Reference Planning application 21/01630/OUT

In response to further documentation provided by Firethorn regarding this development, Elmsbrook Community Organisation (ECO) has major concerns regarding the Executive summary of the Financial Viability Assessment.

Drawing file: 4600-1100-T-011 RevF-Site Access E-Construc E Parcel.pdf

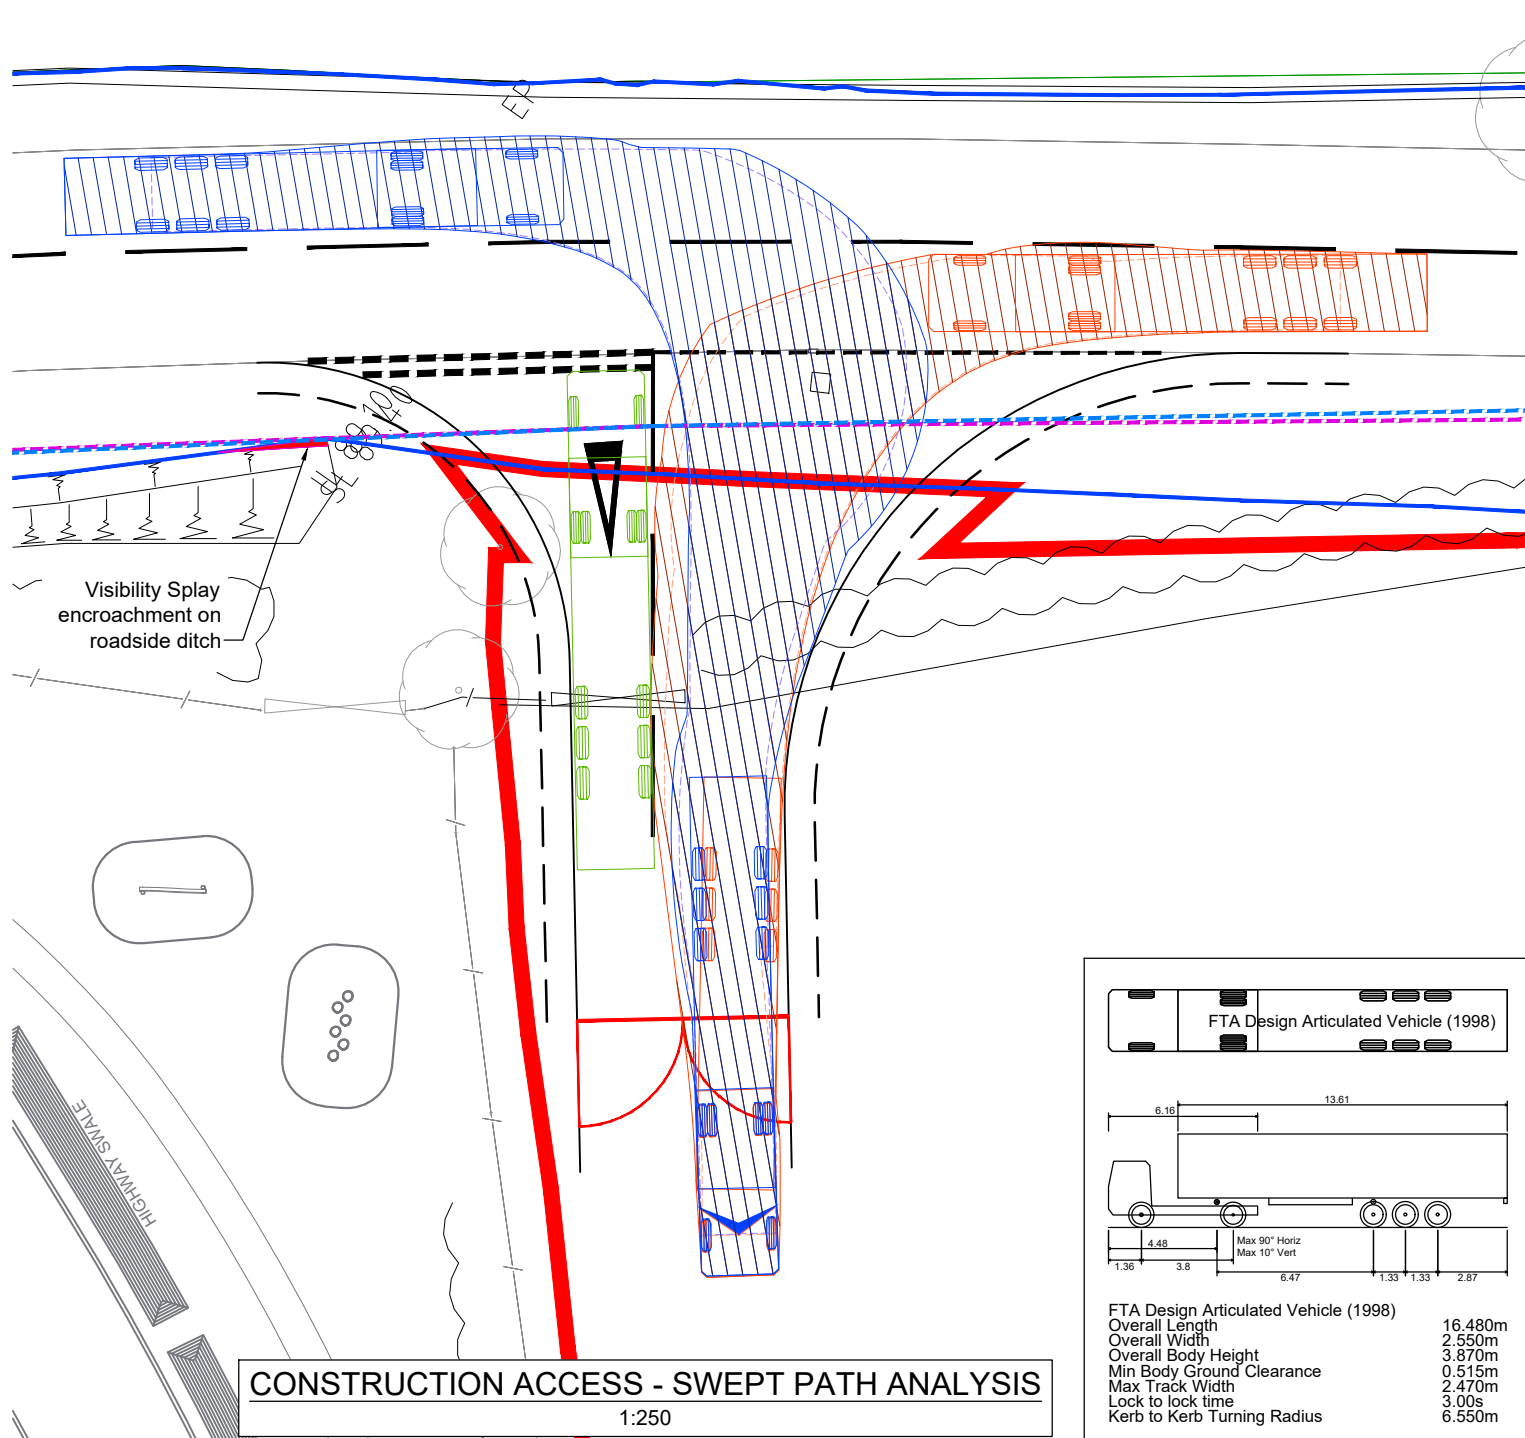
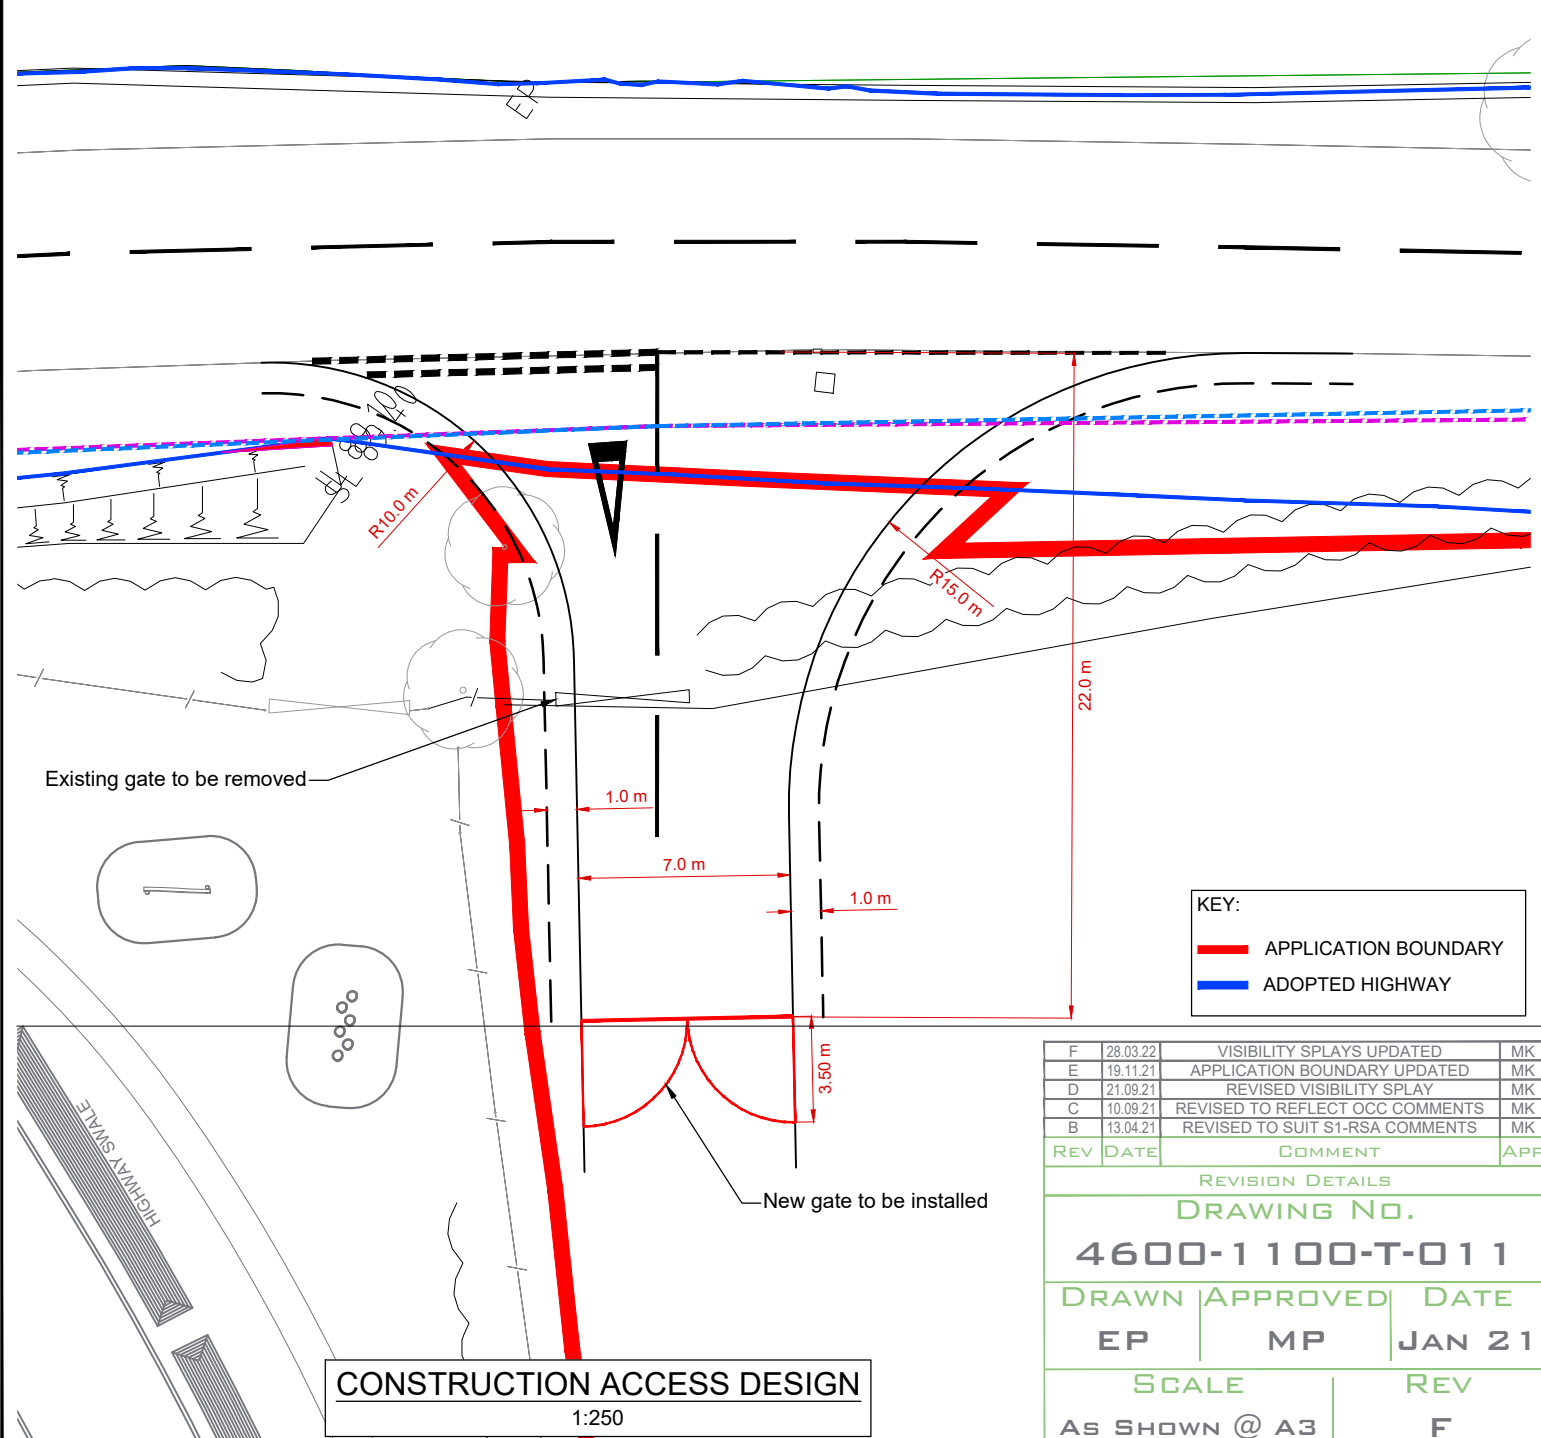
I can also see no response to concerns raised regarding the viability and safety of the designated parking spaces immediately adjacent to the entrance to the eastern parcel of land from Charlotte Avenue.
